**LOWER THAMES CROSSING
DEVELOPMENT CONSENT ORDER EXAMINATION**

WRITTEN SUBMISSIONS at DEADLINE 7

KATHRYN HOMES LTD: Unique Reference 20035583

Comments on the Code of Construction Practice (version 6.0) [REP6-039]

Residents  
External  
Amenity  
Space

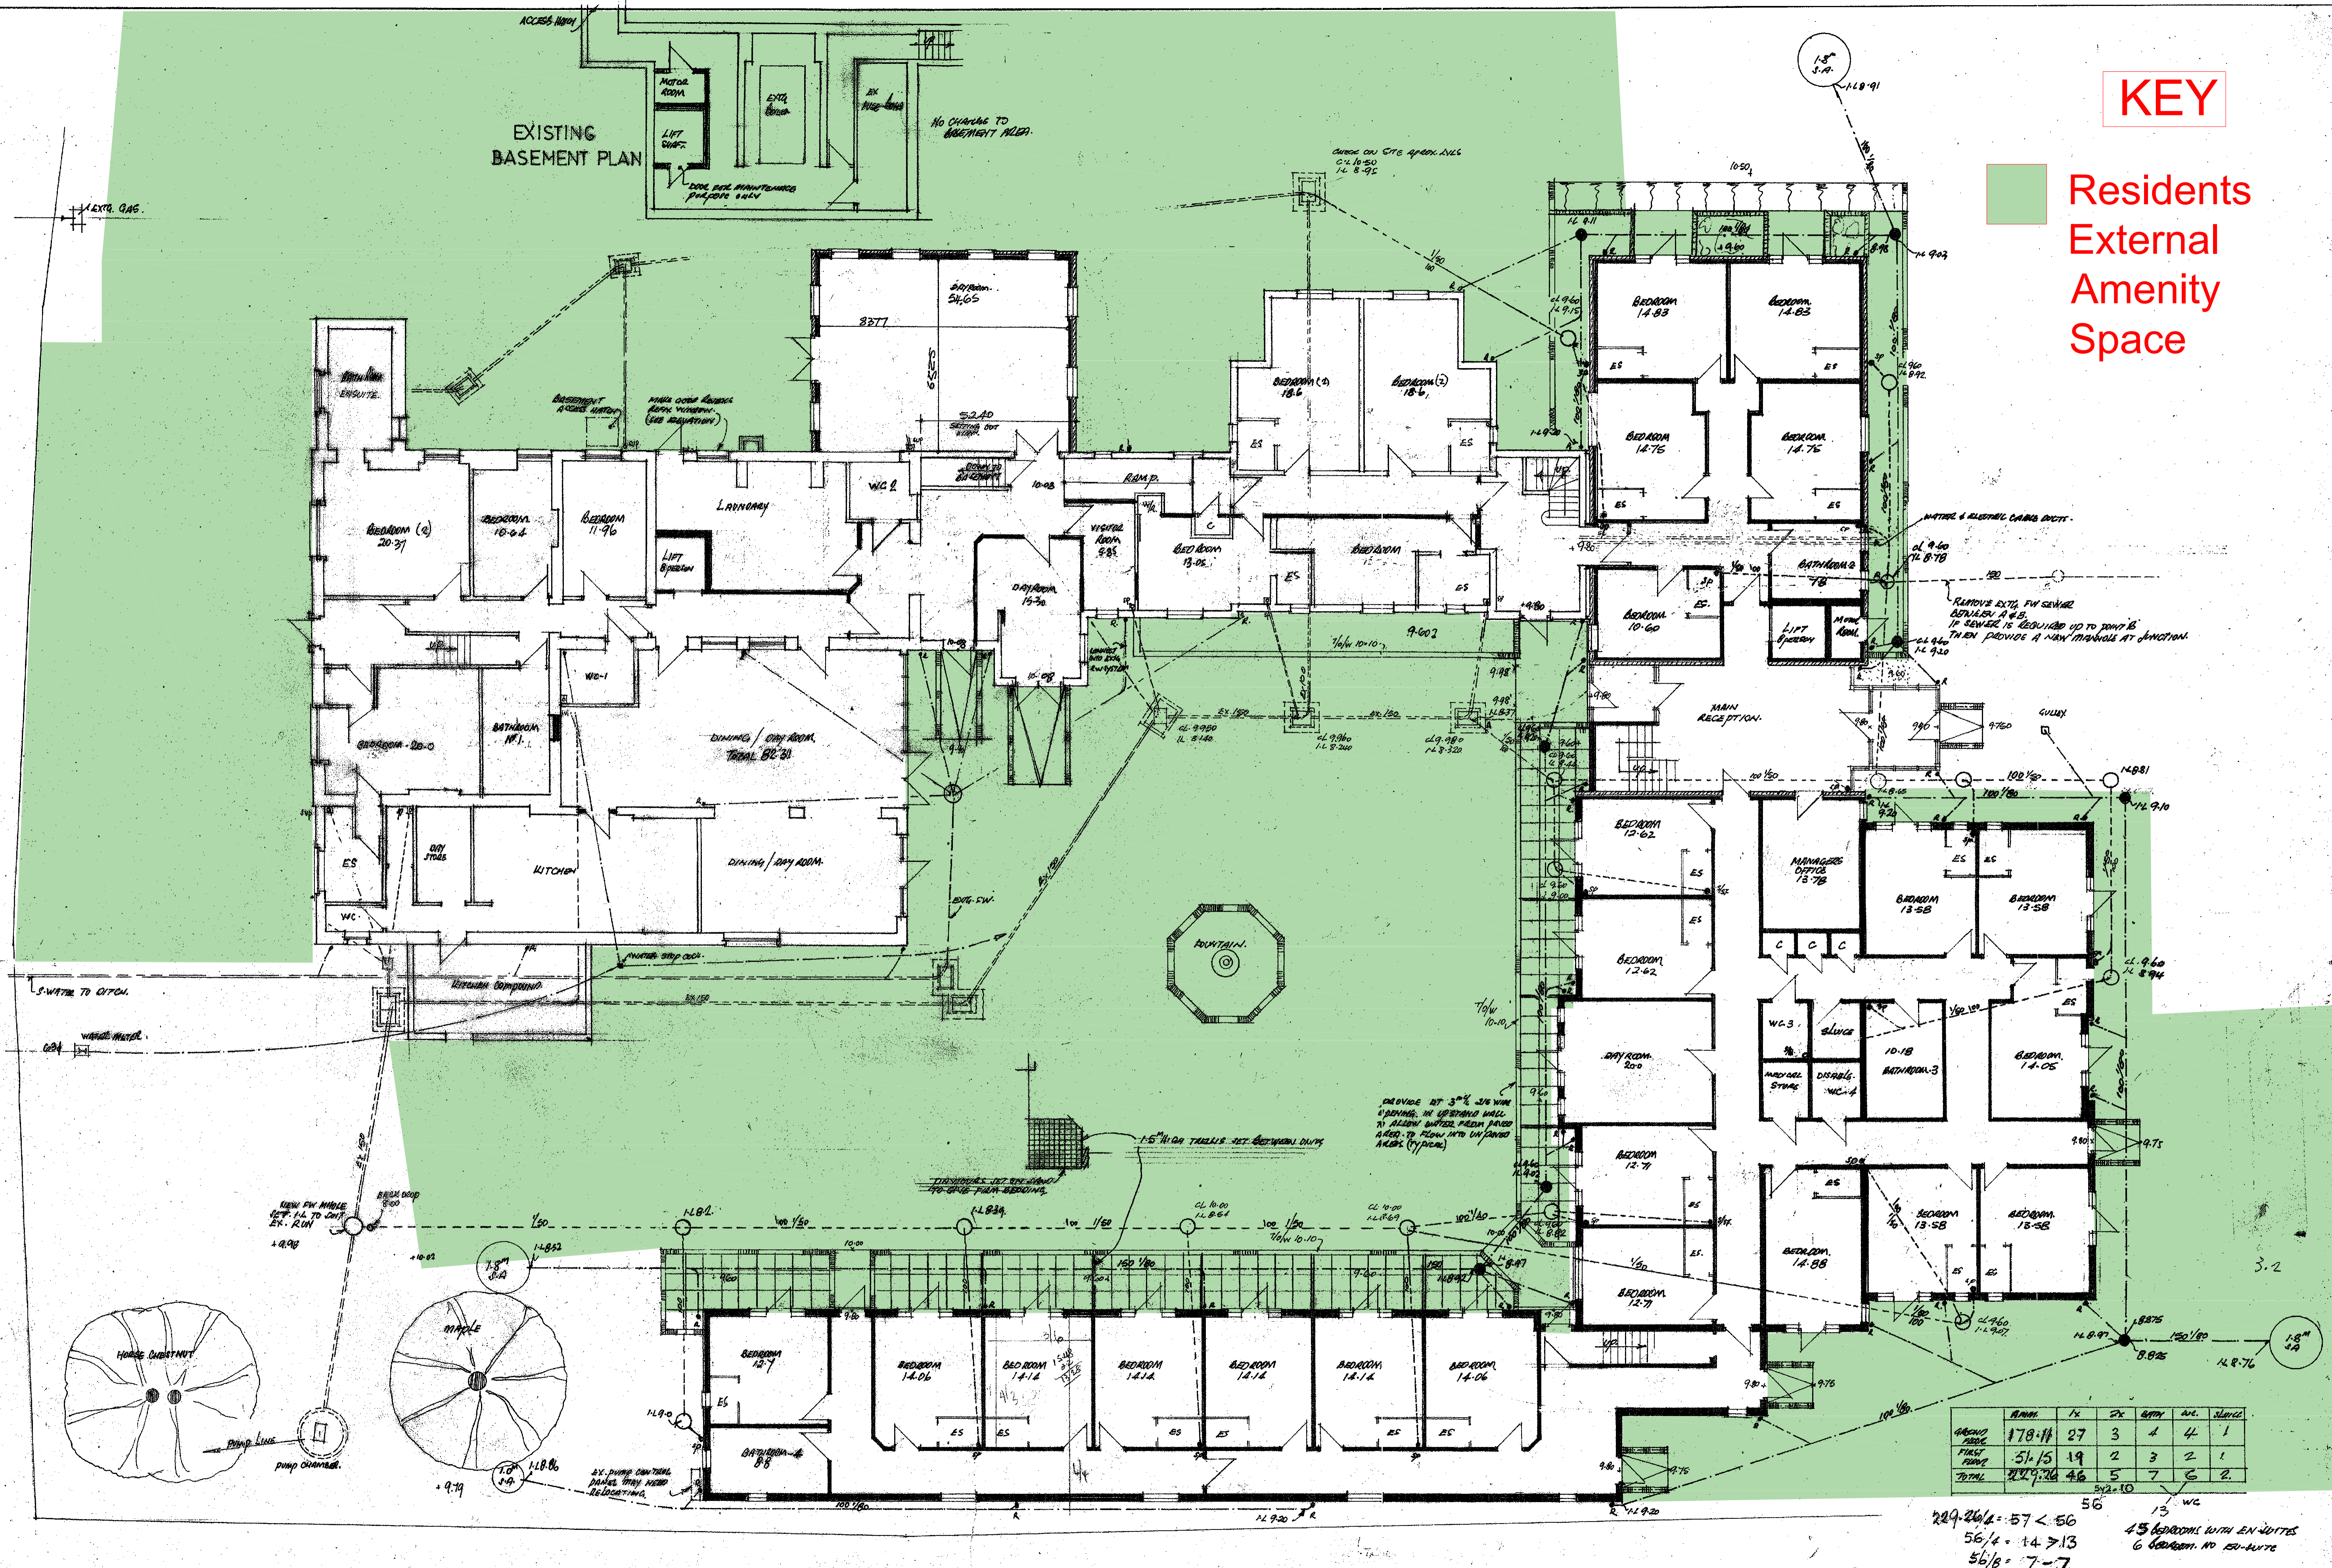
16. Those acoustic screens, especially those to the west of Whitecroft and on Stanford Road will have a marked enclosing impact for the residents, shutting them away from the wider world (including loss of enjoyment of their current rural outlook to the west) and leaving them isolated behind physical barriers. To the extent that they are left with an outlook beyond Whitecroft, predominantly to the south and east, this will be a view of construction traffic on Haul Road 4 and the Stanford Road site compound. They will inevitably feel 'surrounded' by construction activity in every sense.

evening and overnight periods (on p.11) and that there would also be a commitment not to undertake any earthworks activities within 300 metres of any sensitive receptor during daytime and evening periods (on p.12). Since the bund is to be wholly constructed on land which is within 65 metres of Whitecroft (as shown on the Section A cross-section in REP5-092), the Objectors do not understand how it is to be constructed whilst adhering to the claimed limits.
